## Summary Report (v2 October 2023)

This report has been prepared to assess the details provided to discharge conditions 14, 15, 16, 17, 20, 24 and 28 for Bicester Eco Town Exemplar Site, Banbury Road, Bicester under Application Reference 21/01227/F.

**03 Section Detail - Flat Green Roof Garages - Wall type varies**

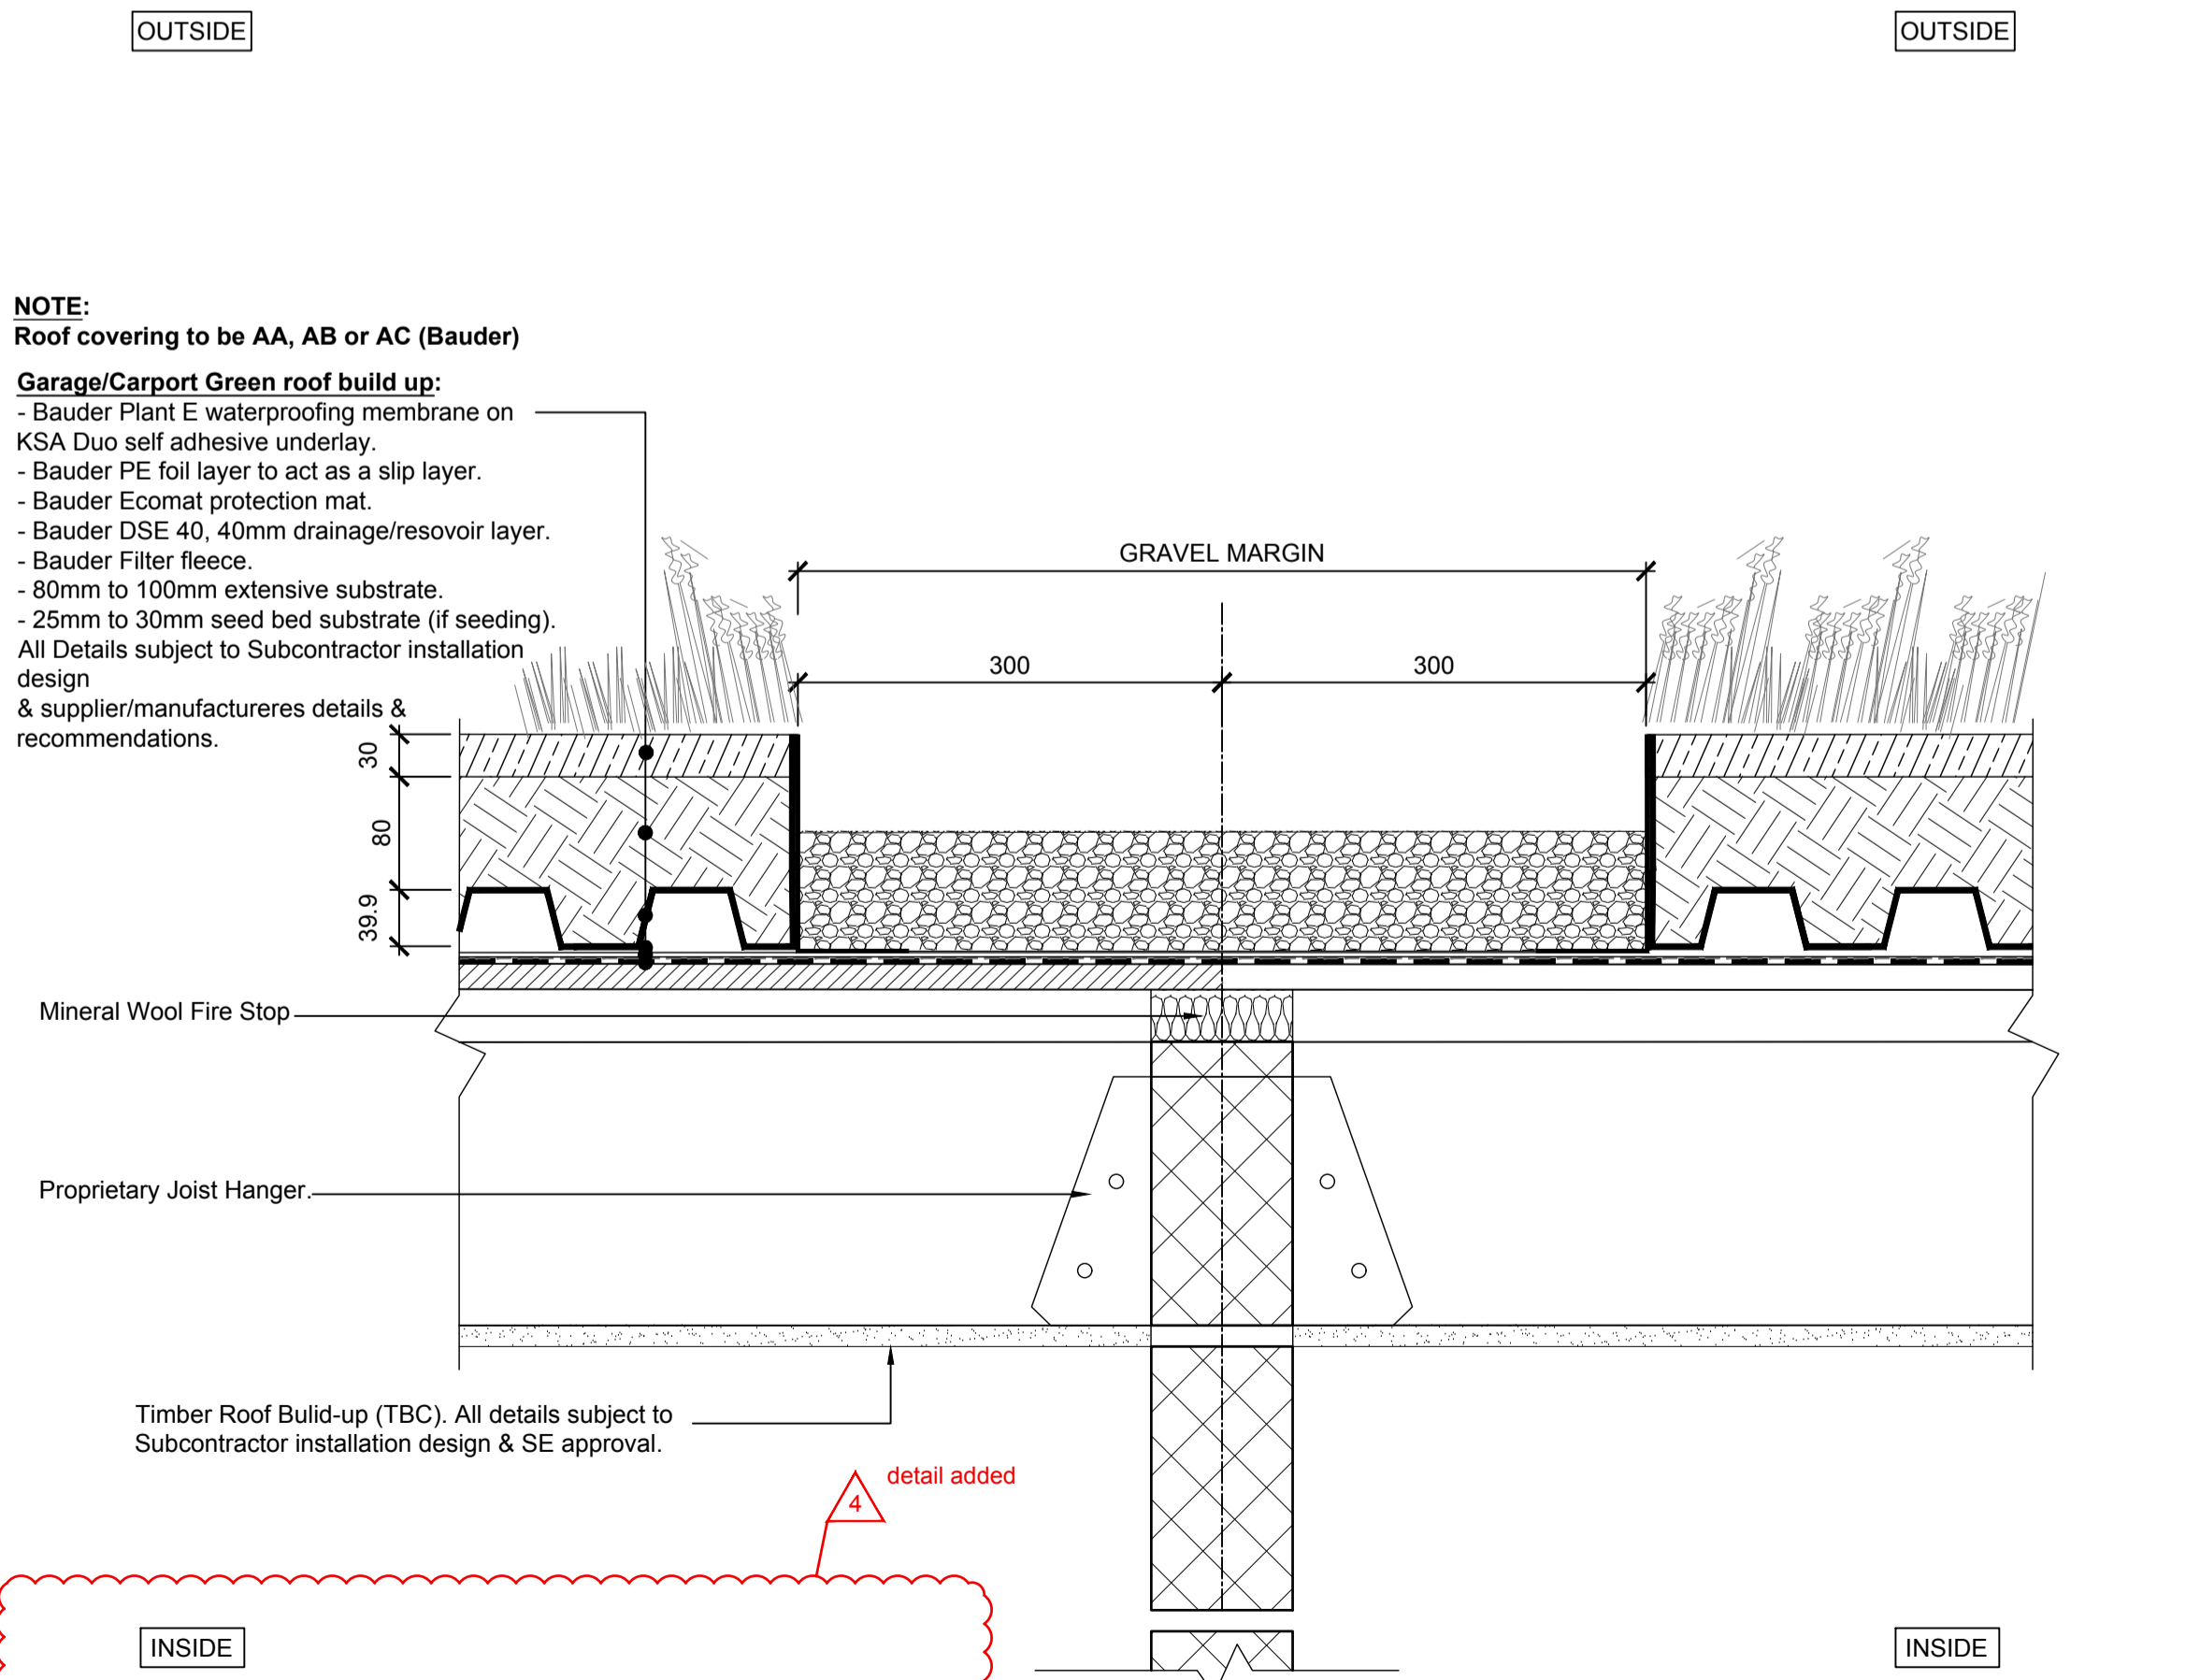
The presented maintenance programme is generic and vague. It is not a detailed maintenance programme that will ensure the delivery and long-term maintenance of the roofs.

The green roof layout plan is not provided and therefore is not possible to assess the arrangement of the green roofs within the development.

Site Name: Detail Drawing			
Drawing Title: HBS PV Mounting Details			
Drawing No: PV-DET-101	Revision: A	Scale: NTS	Papersize: A3
Drawn By / Date: EF - 23/01/18	Checked By: RW	Status: DES	Sheet: 001

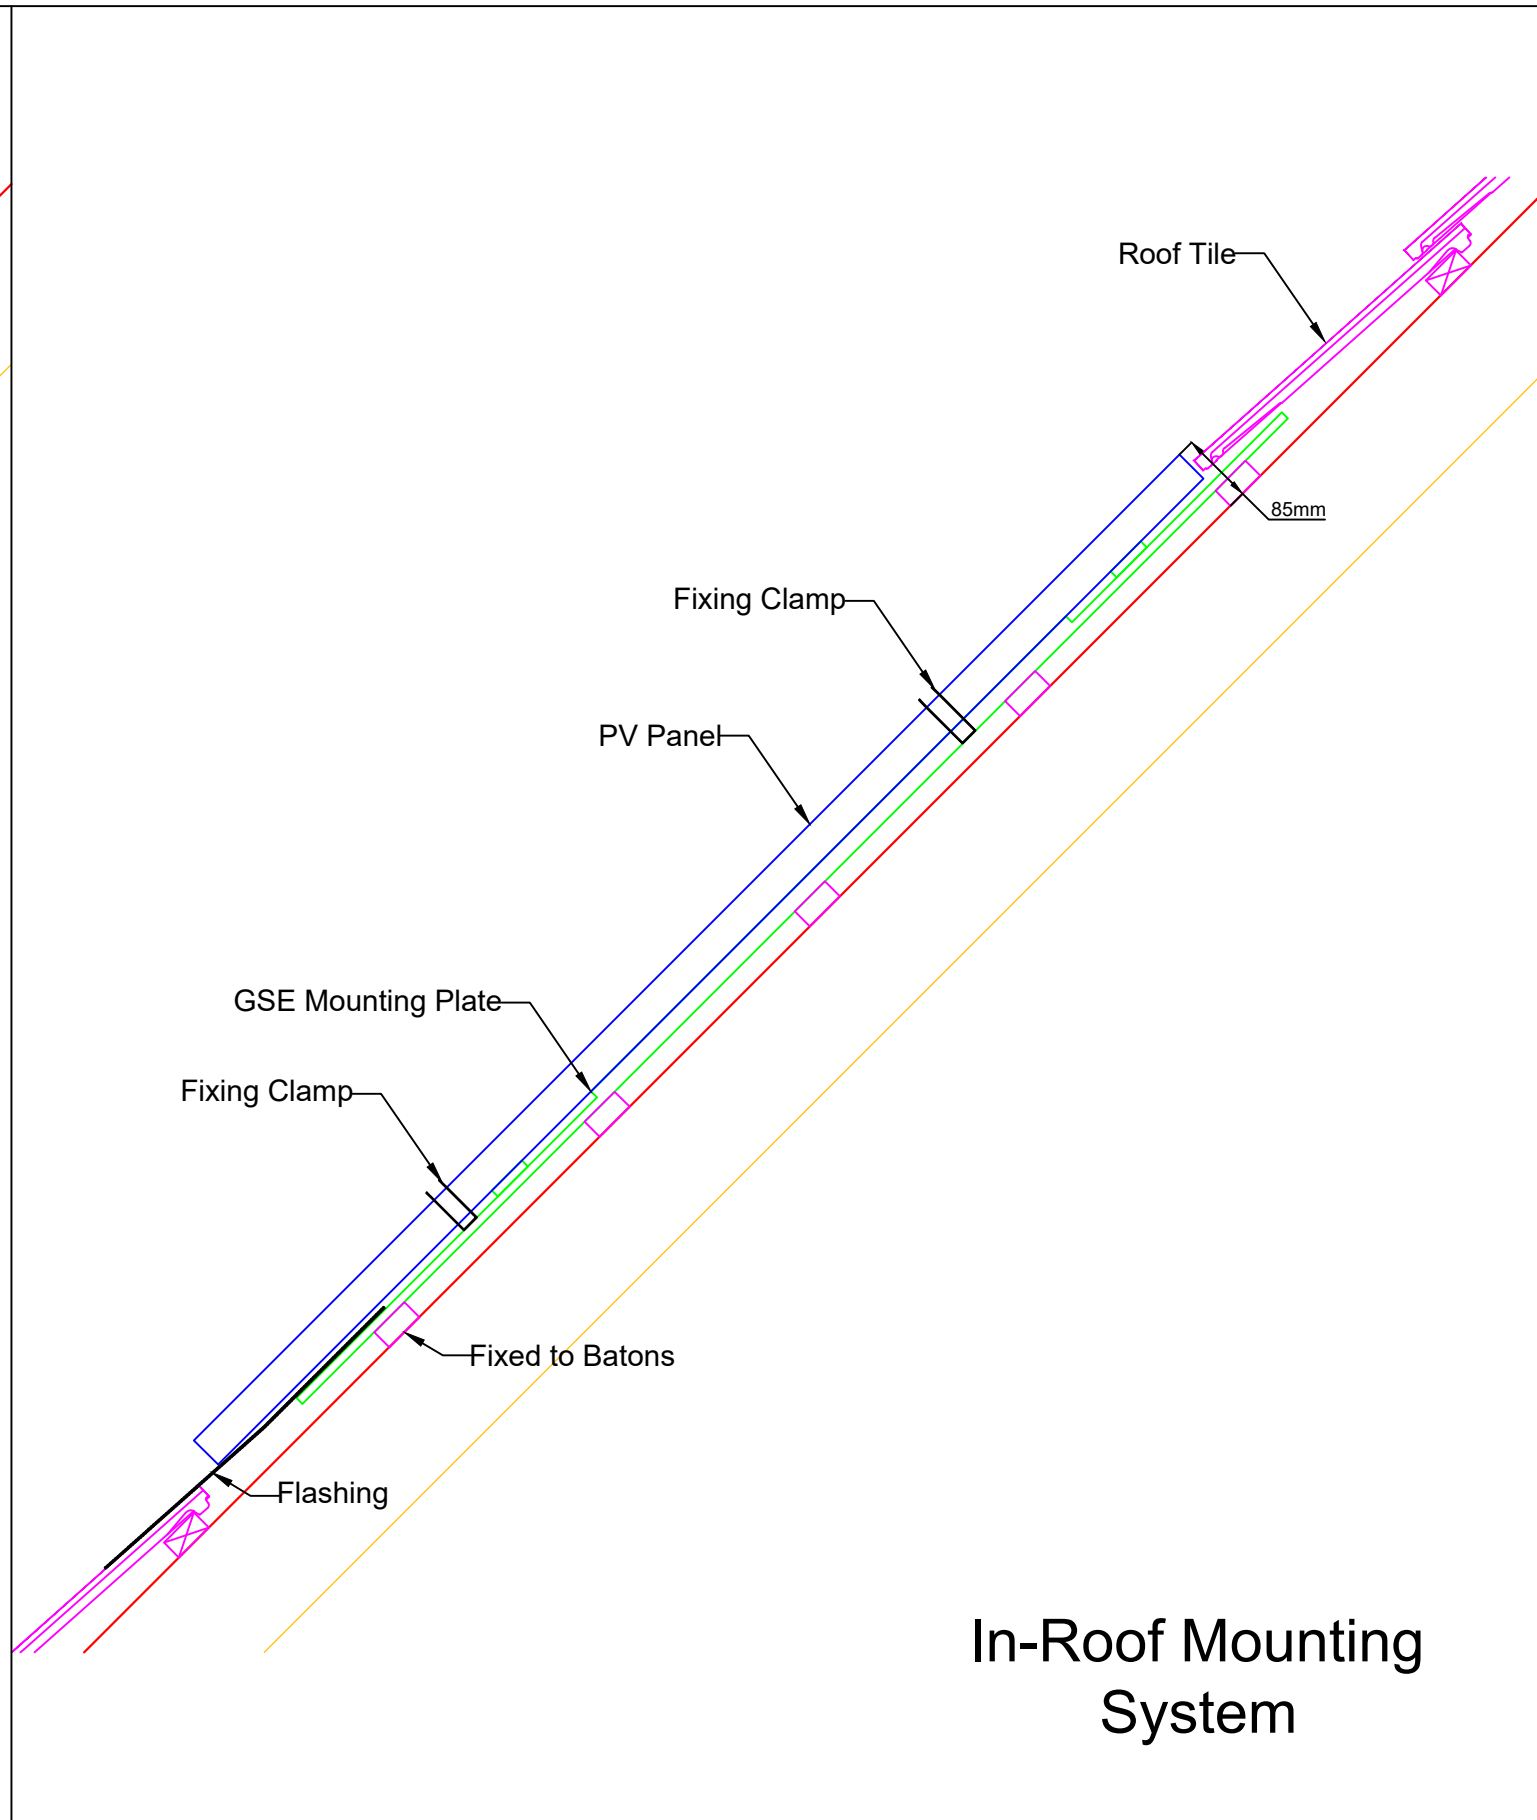
More clarity is required on if the information presented in the carbon equivalent datasheet matches the carbon balance in the Sustainability Statement. The Applicant previously submitted a calculation (no author, dated 9<sup>th</sup> March 2022) of the CO<sub>2</sub> emissions offset by the PV panels for each dwelling. This cannot be matched up to the Energy Statement which states the average kgCO<sub>2</sub> offset from PV by dwelling type rather than by dwelling. It is not clear how many PV panels and the kWp proposed to each dwelling, and how this has been allocated. For example, were south-facing roofs modelled to accommodate more PV? Can any information be provided about the proposed manufacturer, capacity (Watts) or efficiency of the PV panels?
